DOC20/229048

20 March 2020

**The New Sydney Fish Market – Concept and Stage 1 (SSD 8924) and Stage 2 (SSD 8925)
EPA comment on Response to Submissions**

Stage 2 – Dewatering and pile cutoff. Bridge Road upgrade works

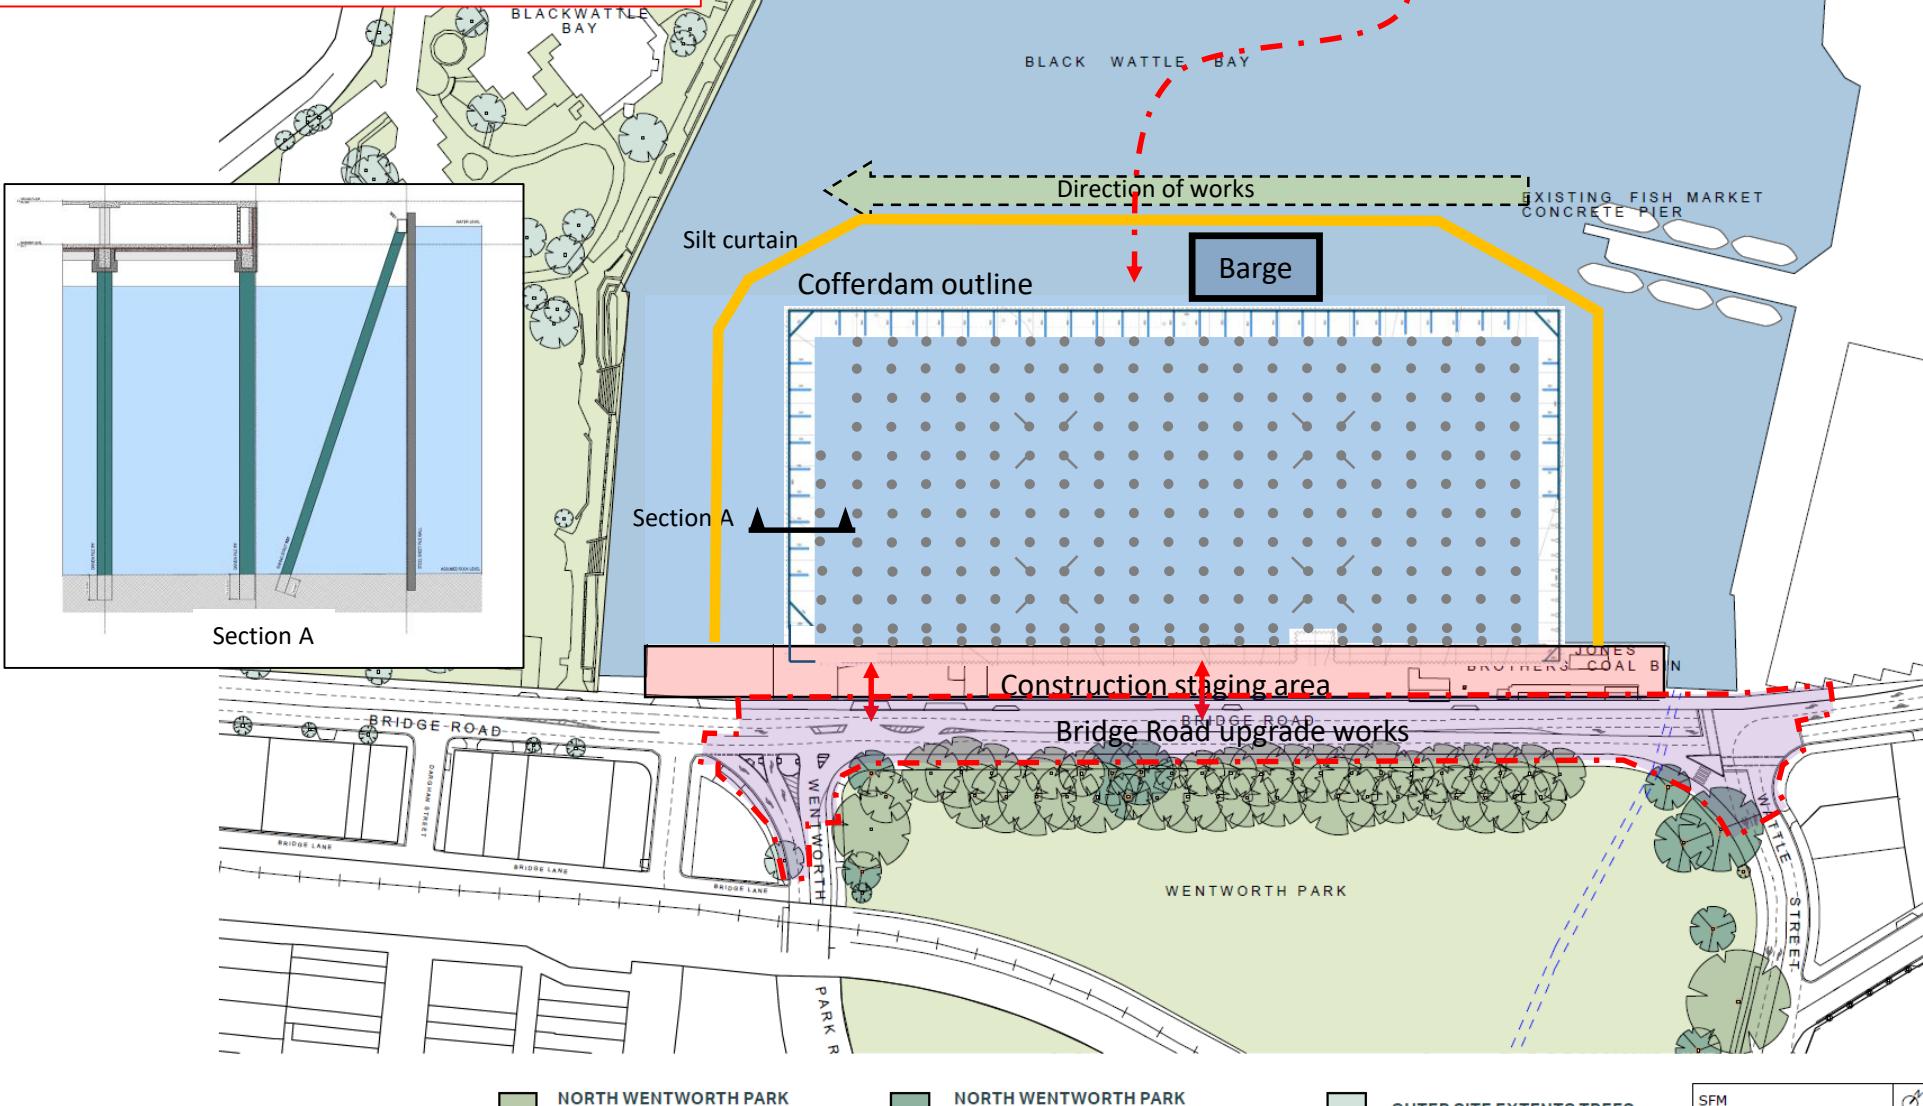
In addition to the EPA's previous recommended condition regarding removal of the cofferdam sheet-piles, it is requested that the following condition also be included in any consent for *Stage 2* (SSD 8925):

1. Prior to dewatering the cofferdam, the applicant must prepare a Dewatering Plan, demonstrating that dewatering will not result in the discharge of pollutants at non-trivial levels. This plan must include, at a minimum:
 - a description of the dewatering process, monitoring methods, management triggers and actions, and discharge location;
 - a characterisation of the expected quality of the proposed discharge in terms of the concentrations and loads of all pollutants present at non-trivial levels;

- an assessment of the potential impact of the discharge on the environmental values of the receiving waterway with reference to the relevant Australian and New Zealand Guidelines for Fresh and Marine Water Quality guideline values; and
- where relevant, details of measures proposed to mitigate any identified impacts.
